# **East Anglia ONE North and East Anglia TWO Offshore Windfarms**

## **Applicants' Responses to Examining Authority's Written Questions 3**

### **Volume 8 – 3.11 Marine and Coastal Physical Processes**

Document Reference: ExA.WQ-3.D10.V1\_08

Coralline Crag

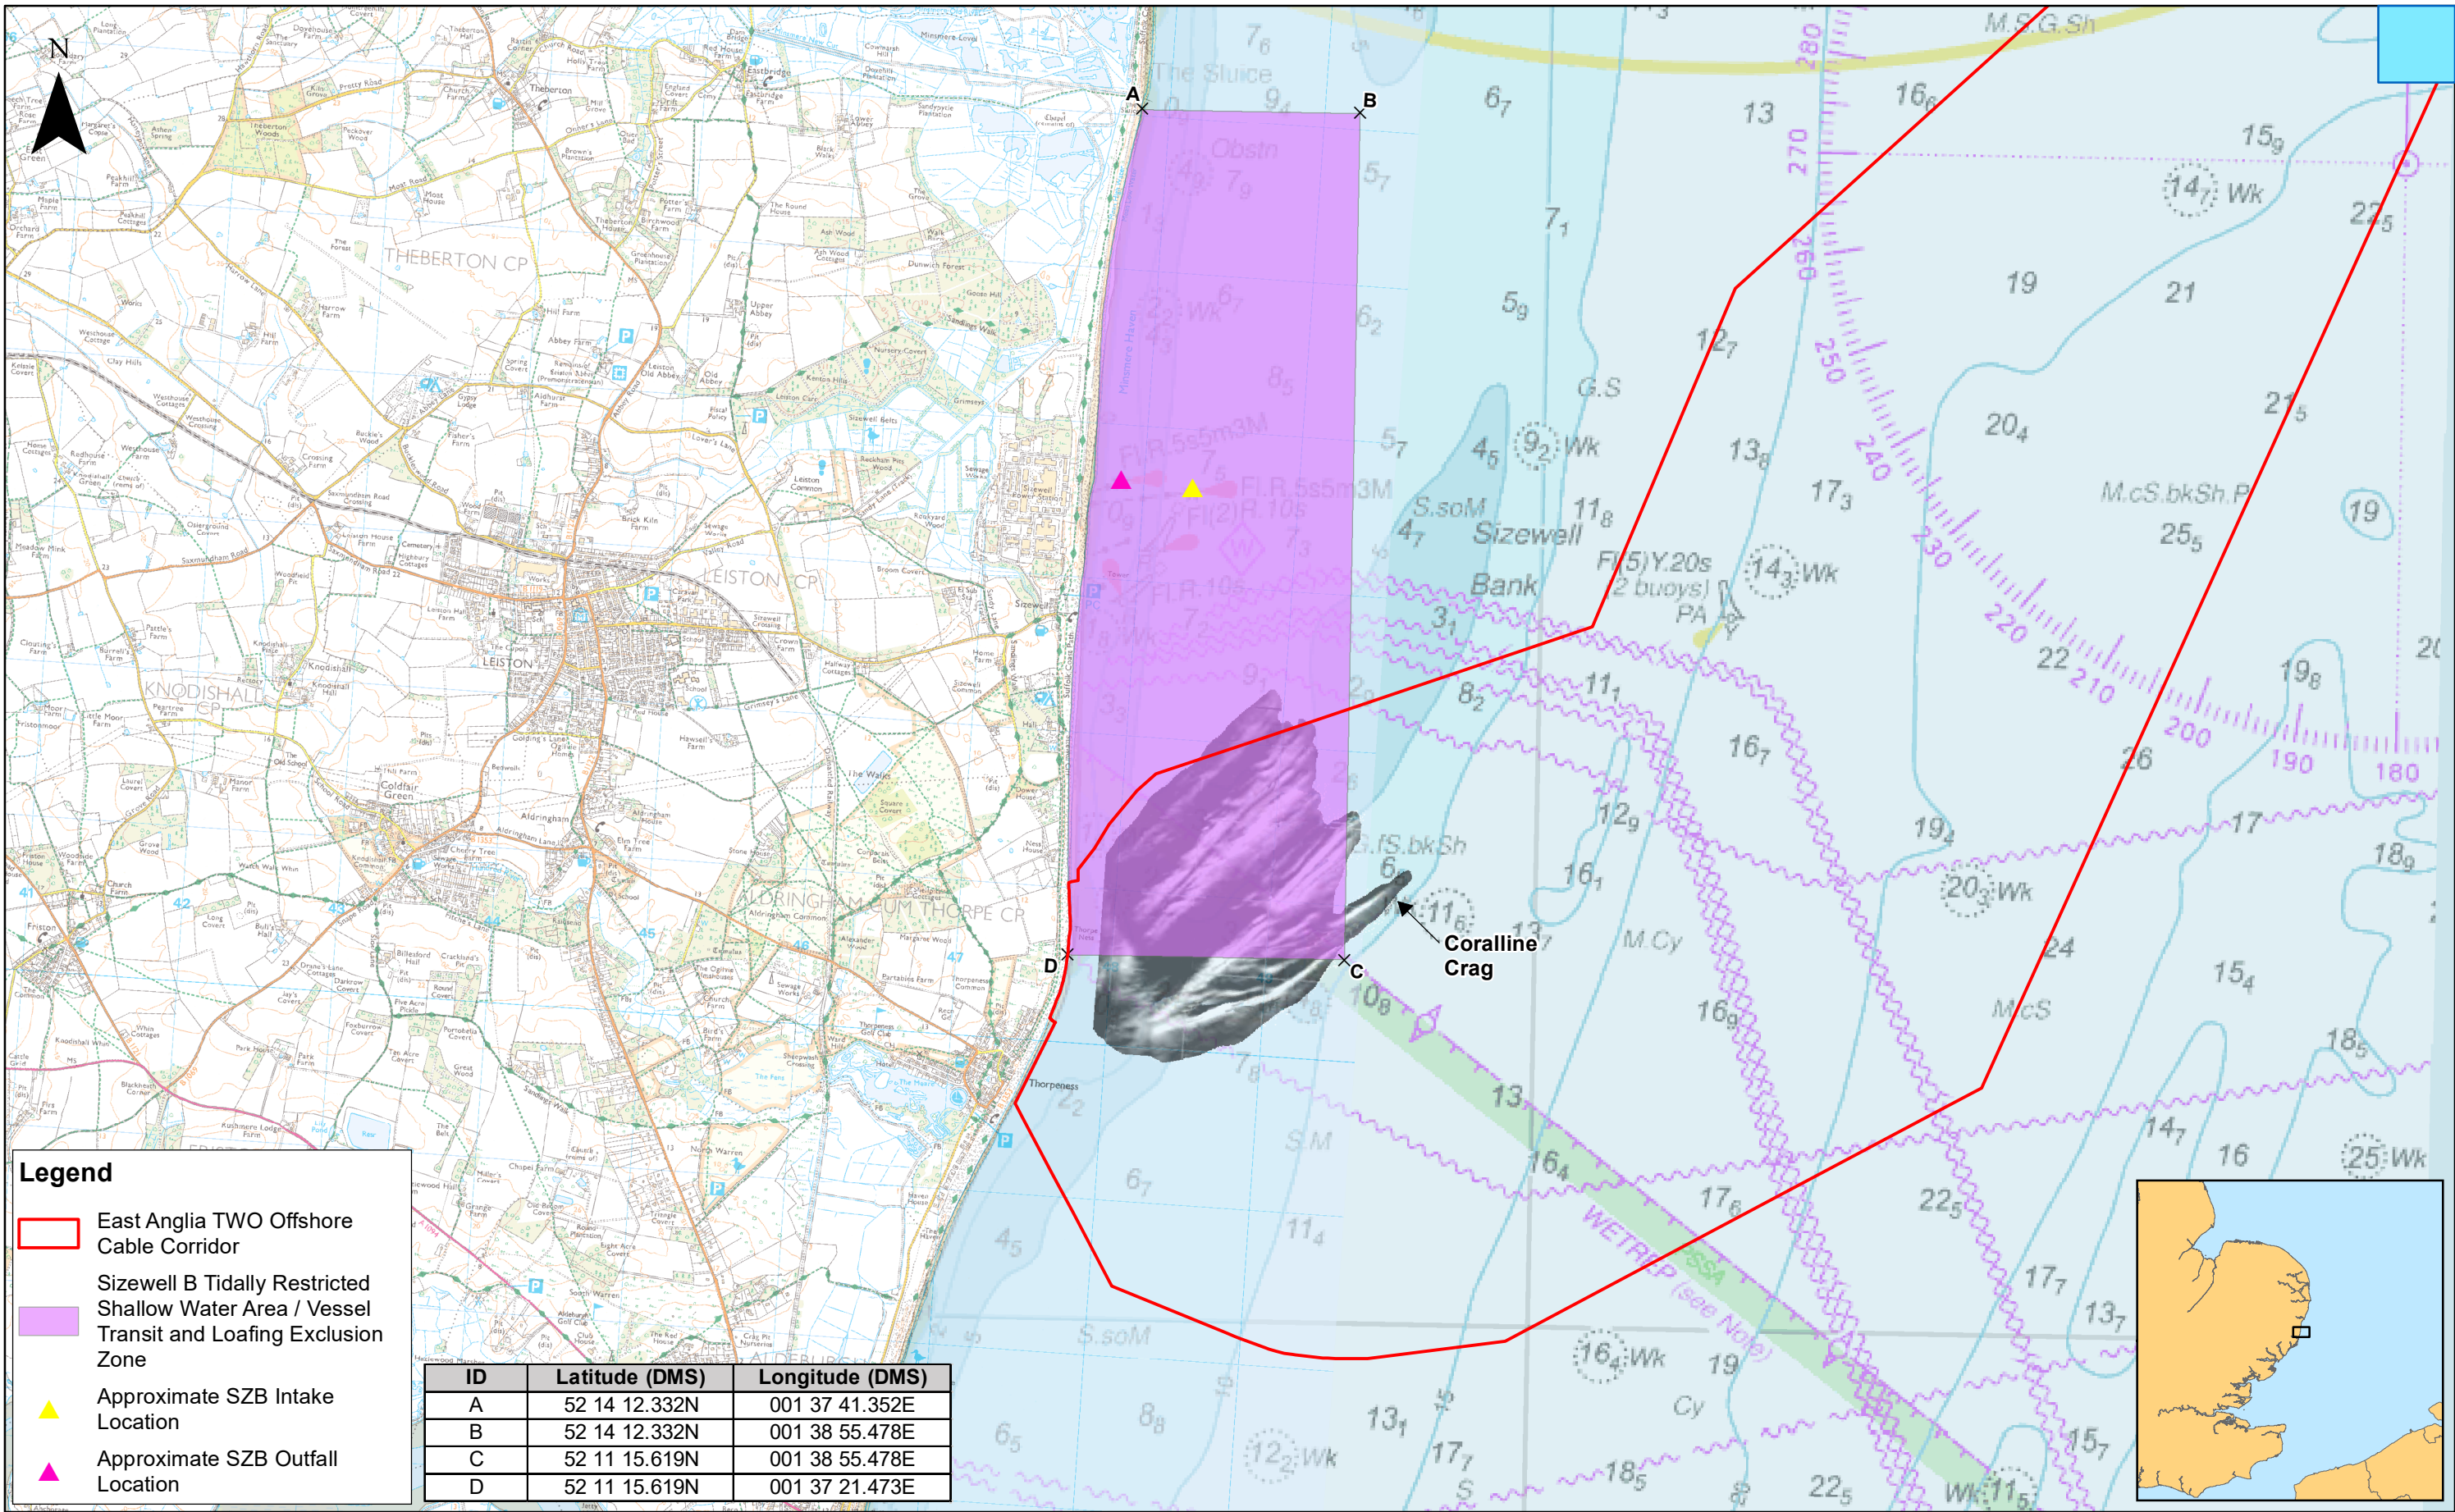
ExA. Question addressed to Ref.	Question	ExA. Question	Applicants' Response
<b>3.11 Marine and Coastal Physical Processes</b>			
3.11.1	EDF Energy Nuclear Generation Ltd, ESC, MMO	<p><b>Avoidance of the Coralline Crag</b></p> <p>Paragraph 15 of the Landfall Hydrogeological Risk Assessment [REP6- 021] states that the HDD is expected to be within the Coralline Crag beneath the cliffs, and the strength of the Coralline Crag is expected to prevent any drilling fluid breakout at this point. In [REP8-052] the Applicants state that complete avoidance of the Coralline Crag has never been proposed. The Applicants go on to state any reference to avoiding direct physical disruption to the outcrop of Coralline Crag refers to the parts of the Crag that are visible at the surface; the HDD bores as proposed pass through the Coralline Crag, but beneath its visible surface before 'punching out'.</p> <p>a) Please could you confirm that in referring to the avoidance of direct physical disruption to the outcrop of Coralline Crag it was also your understanding that this meant only those parts visible at the surface and that the HDD bores would in fact pass through the Coralline Crag?</p> <p>b) If this was not your understanding does this cause any concern and what would be the implications?</p>	<p>The key matter pertaining to the Coralline Crag is avoiding punching-out within the visible extent of the Coralline Crag (i.e. where the Coralline Crag is visible on the seabed) to mitigate concerns raised by EDF that punching-out within the visible extent could affect coastal processes and place the cooling water infrastructure of Sizewell B at risk. To this end, the Applicants have made a commitment to avoid punching out in the visible extent of the Coralline Crag, which is secured through Schedule 10, Part 7 (Protection for EDF) of the draft Development Consent Order (DCO):</p> <p><i>5.—(1) The undertaker shall consult with EDF Energy in the preparation of the landfall construction method statement prior to submission of the landfall construction method statement to the relevant planning authority for approval in accordance with requirement 13.</i></p> <p><i>(2) Prior to carrying out Work No. 6, the undertaker shall carry out geophysical surveys to confirm the visible extent of the Coralline Crag formation and shall provide the results of such surveys to the extent that they demonstrate the visible extent of the Coralline Crag to EDF Energy on completion.</i></p> <p><i>(3) The undertaker must not undertake cable trenching activities or locate the HDD punch out within—</i></p> <p><i>(a) the Punch Out and Trenching Restriction Area shown on the Activity Exclusion Zones plan (Drawing No. EA2-DEV-DRG-IBR-001259); or</i></p>

ExA. Question Ref.	Question addressed to		ExA. Question	Applicants' Response
				<p><i>(b) the visible extent of the Coralline Crag as confirmed by the surveys undertaken under sub-paragraph (2), unless otherwise agreed with EDF Energy (such agreement not to be unreasonably withheld or delayed).</i></p> <p>East Suffolk Council (ESC) and EDF confirmed at Issue Specific Hearing 4 pn 19 January 2021 (between timestamps 1:08:10 to 1:16:21 <b>Issue Specific Hearing 4 (ISH4) (Session 2) - Transcript - 19 January 2021</b> [EV-056]) that reference to the avoidance of direct physical disruption to the outcrop of Coralline Crag meant only those parts visible at the surface:</p> <p>At timestamp 1:15:13, Paul Patterson (Senior Coastal Engineer, ESC) asked the following question:</p> <p><i>I understand that you're seeking agreement from SPR that the PunchOut will be 100 metres away from the Coralline crag. Can I just clarify that I presume that you mean that it will be 100 metres away from the point where the Coralline crag is visible on the surface of the seabed. Is that correct?</i></p> <p>To which, Angus Bloomfield (EDF) responded;</p> <p><i>Paul, to answer your question, that is our expectation as well because yes, the Coralline crag could extend considerably further below the seabed. So yes, the extent surveyed where the Coralline Crag is exposed above the seabed.<sup>1</sup></i></p>
